WELWYN HATFIELD COUNCIL – DEVELOPMENT CONTROL
DELEGATED REPORT

APPLICATION No:	S6/2007/1783/FP
------------------------	------------------------

The proposal seeks full planning permission to extend the ridge to the south to enable an additional dormer to be sited in the front plane of the building, a hipped roof over the garage – the existing would be demolished and a new garage built in front of the existing in line with the southern front boundary. To the rear, the existing conservatory would be demolished to enable a two storey rear extension to be built across the rear/side. To the northern rear/side, a single storey extension is proposed with a flat roofed dormer proposed within the roof space

Drawn LW	Date Oct 07	Scale 1:100@ A1
Job No 2007/57	Drawing No PL 011	Revision

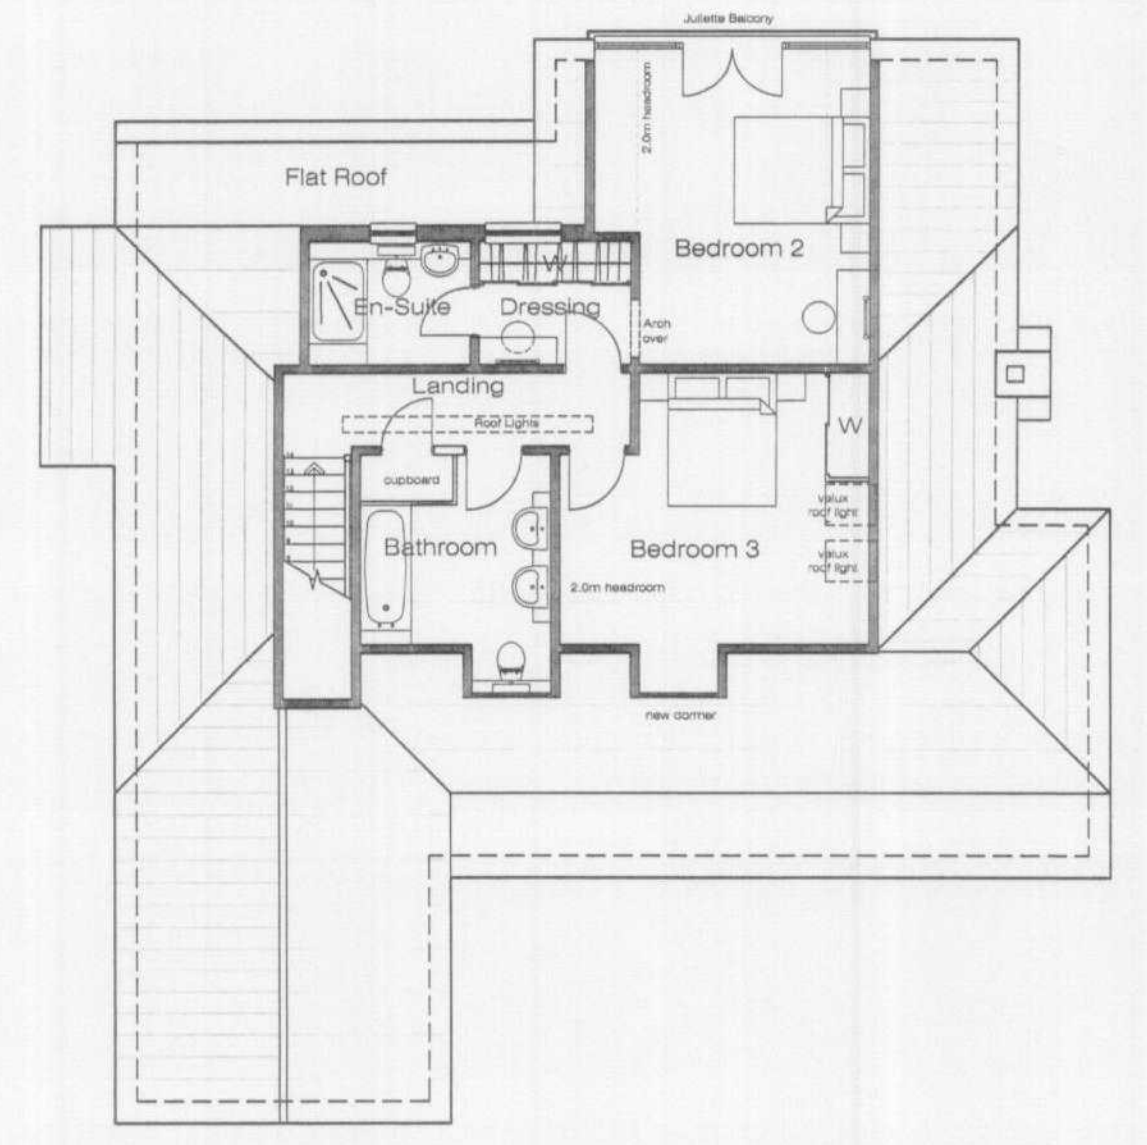
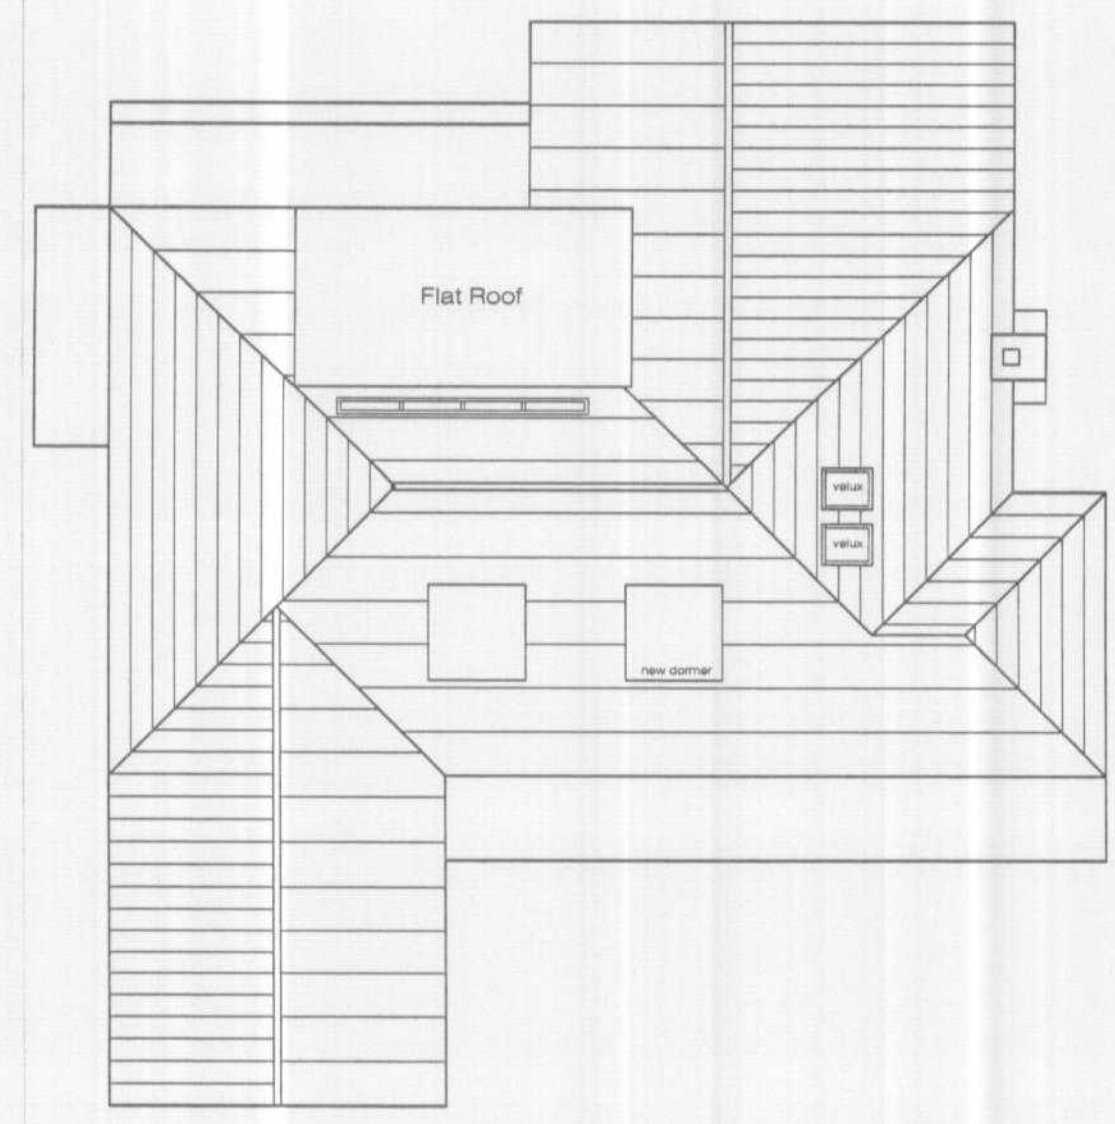
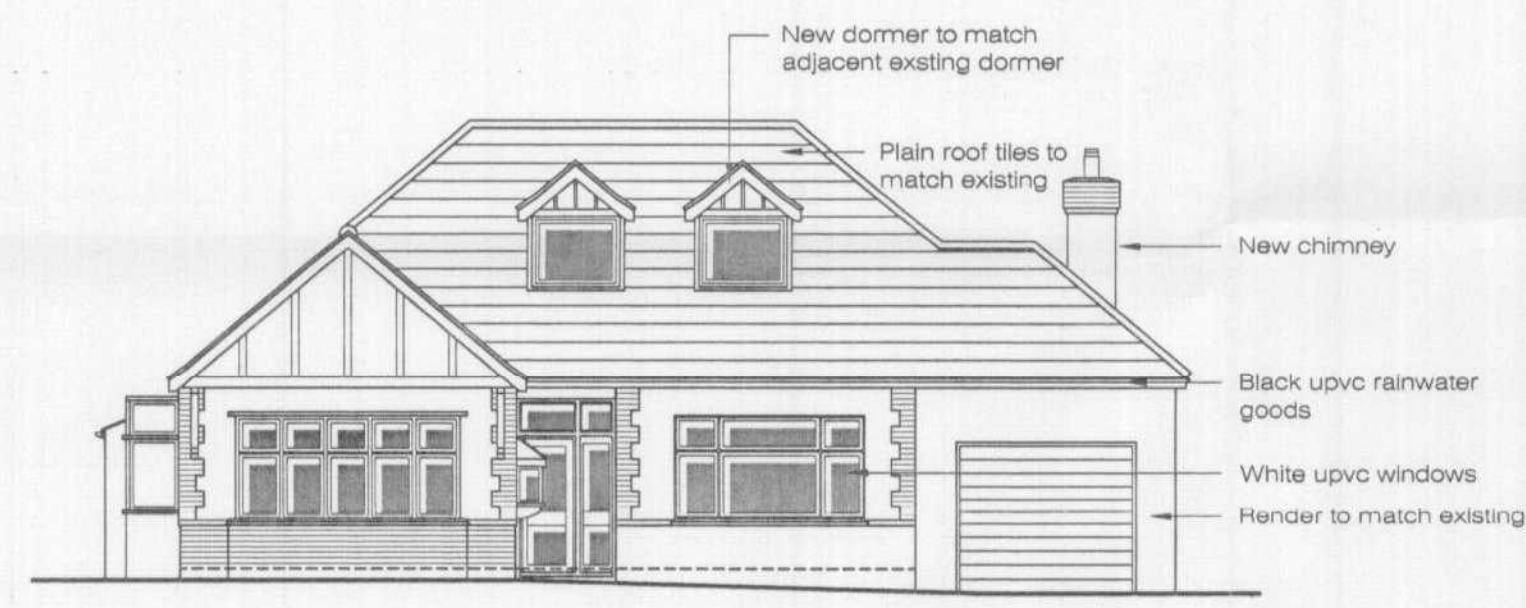
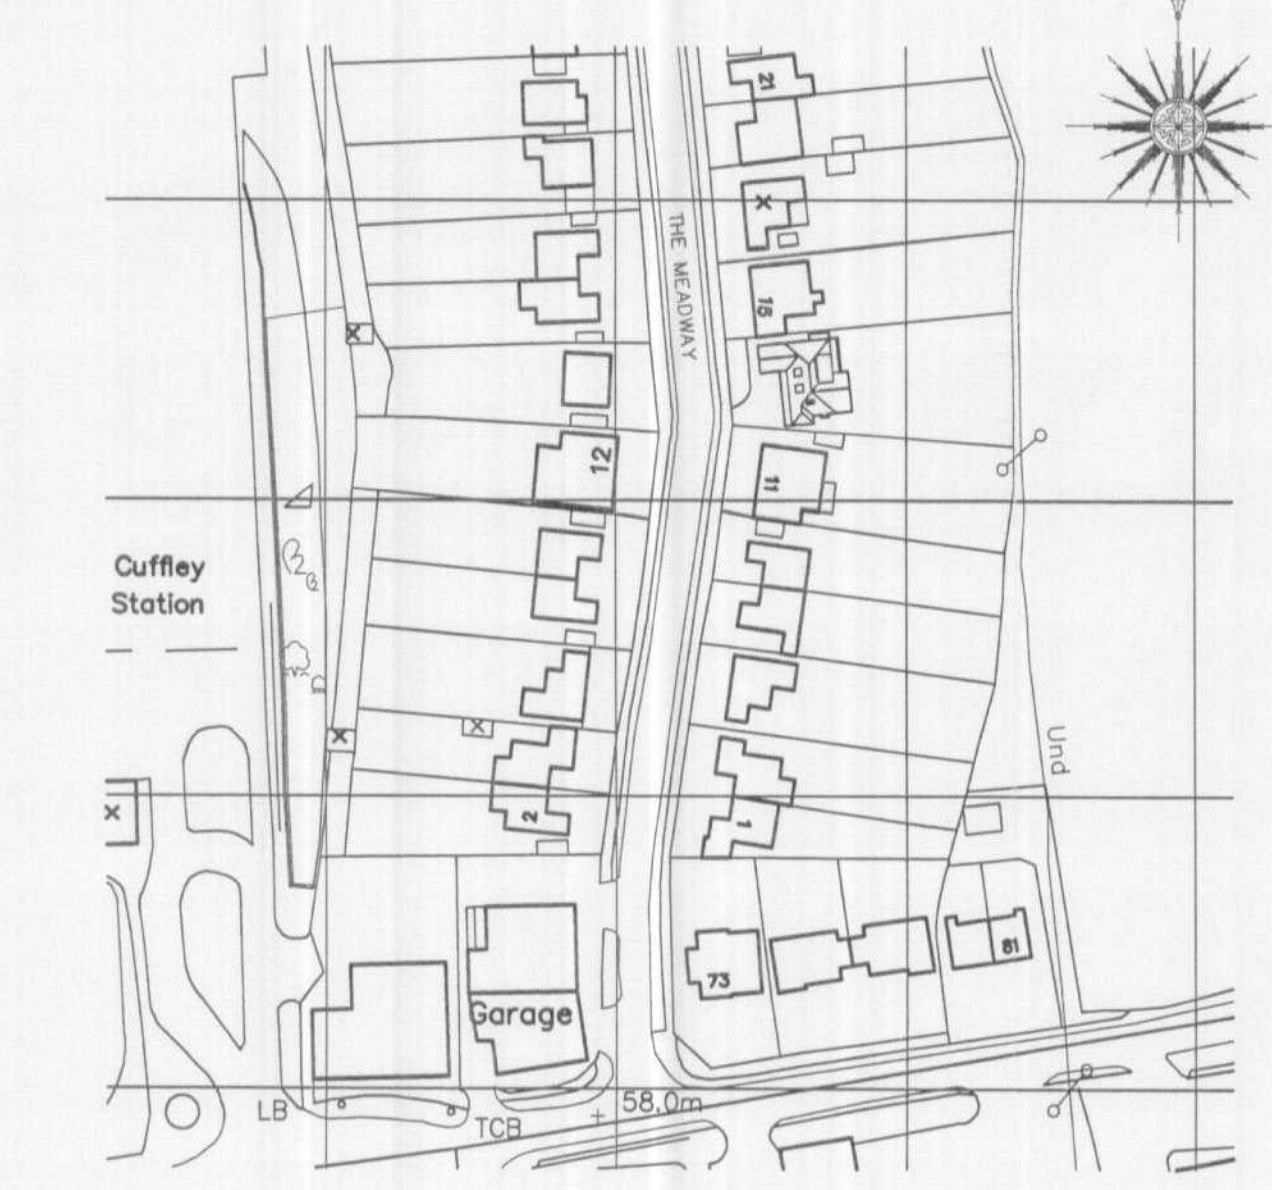
With regards to the two new dormer windows, the dormer to the front is designed to reflect the design and scale of the existing dormer and with the increased width of the ridge/roof, is considered to meet the aims of the design guidance. The dormer to the rear is bulkier spanning the whole of the width of the roof (between the two storey extension and the flank elevation. The bulk of this, notwithstanding that it set some distance from the ridge of the roof, is considered to be detrimental to the overall appearance of the dwelling to the rear.

The extension to the side of the dwelling to provide the garage is considered by virtue of its proximity to the boundary and by virtue of being brought forwards compared to the existing garage would impact upon the amenity of number 11. This dwelling (11), to the flank elevation adjacent to number 13 has a bedroom to the front, a small bedroom behind this, then a bathroom and finally kitchen. The front bedroom has windows facing the front and the kitchen, windows to the rear and it is therefore considered that the proposal would not impact upon the amenity to either of these two rooms.

The proposal would retain the same number of bedrooms as currently exists in the dwelling (3). However, although a garage is shown on the plans, replacing the existing, it is considered by virtue of the proposed dimensions 2.3 x .4.4 metres (manoeuvrable space) that this is below the required parking space standards and would therefore not contribute towards parking provision.

1. The proposed side extension by virtue of its proximity to the common boundary with number 11 The Meadway would result in an unacceptable loss of residential amenity currently enjoyed by occupiers of that dwelling due to the significant loss of daylight and outlook to the existing side window of a ground floor bedroom of this neighbouring dwelling. The proposal is, therefore, contrary to the design standards required by policy D1 of the Welwyn Hatfield District Plan 2005 and the accompany Supplementary Design Guidance, February 2005 and Planning Policy Statement 1 (Delivering Sustainable Development), both of which seek to achieve good quality design which respects the environmental amenity for both existing and new developments.

2. The proposed rear dormer by virtue of its width is considered to not be subservient or in proportion to the fenestration of the dwelling and so contrary to the requirements of policy D1 of the Welwyn Hatfield District Plan 2005 and Supplementary Design Guidance, February 2005 and the design requirements of Planning Policy Statement 1 (Delivering Sustainable Development).

1. For information, the internal dimensions of the garage as shown on drawing PL011 does not meet the minimum parking space standards and would provide insufficient area for the parking of cars.
